Planning Officer: Amber Willard
Planning Application Ref: AW/13/18/T
Location: 1 The Drive, Aldwick
Description of works: Reduce crown by 25% to 4 Holm Oak trees
Reasons Given: To ensure they remain safe and healthy.
Comments On Application:

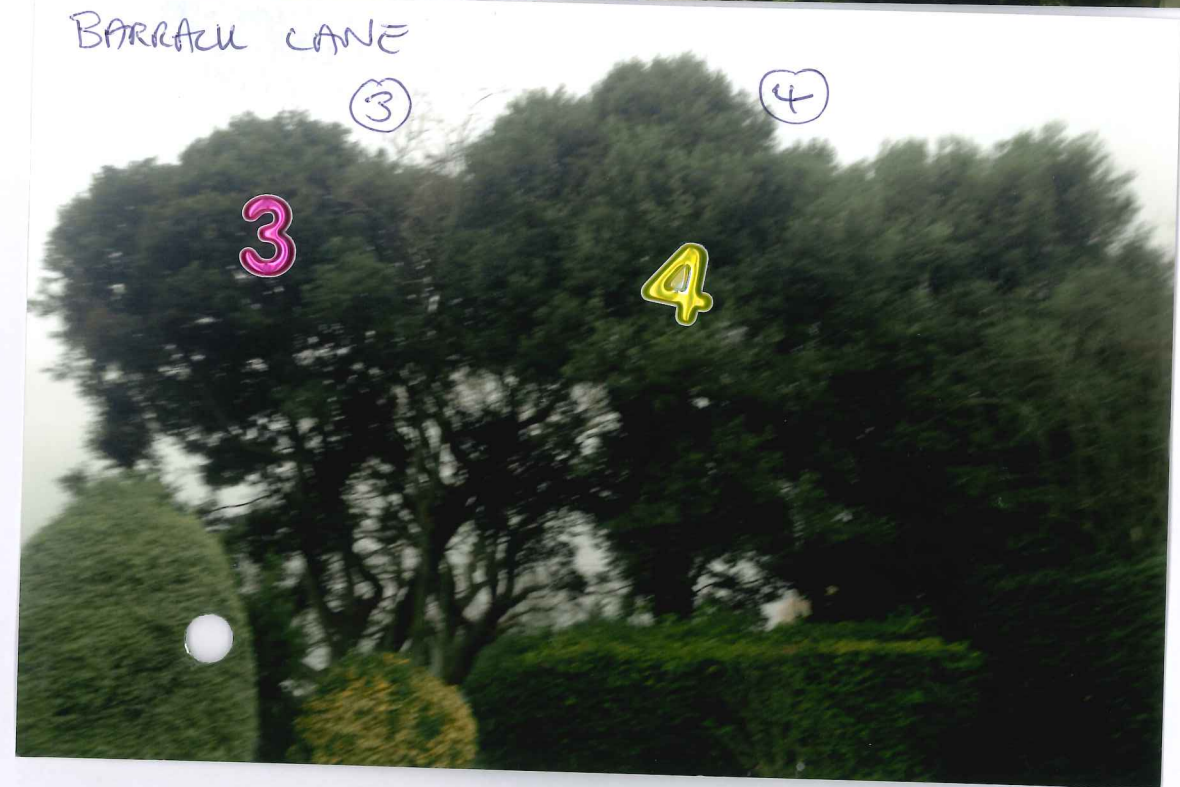
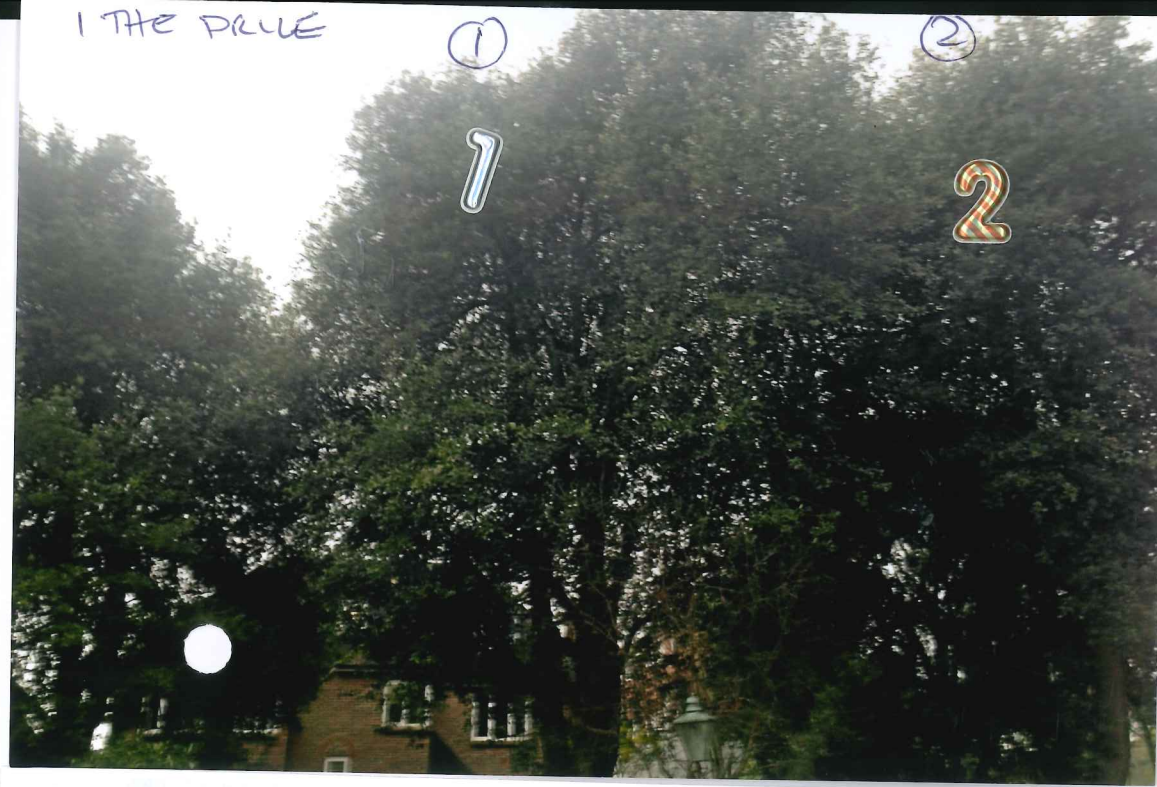
- The extent of proposed crown reduction work has been incorrectly specified as a percentage, rather than in metres. I have calculated that a 25% reduction in height and spread would result in approximately 50% reduction of crown volume. Nevertheless I am able to determine the application as it stands, as it has not been demonstrated that an overall reduction of tree height and spread (to any extent) is justified on arboricultural grounds.

- Where there is an obvious history of crown reduction work (T1 and T2) – they have ‘grown out’ well and all display attractive crown profiles characteristic of their species.

- These trees are a significant feature in the local landscape and appear to be in adequately sound and healthy condition. The tree surgery proposed in the application would result in excessive reduction of their landscape impact and undue detriment to the visual amenities of the locality, in conflict with policy GEN7 of the Arun District Local Plan.

- I recommend **REFUSAL** for this application.
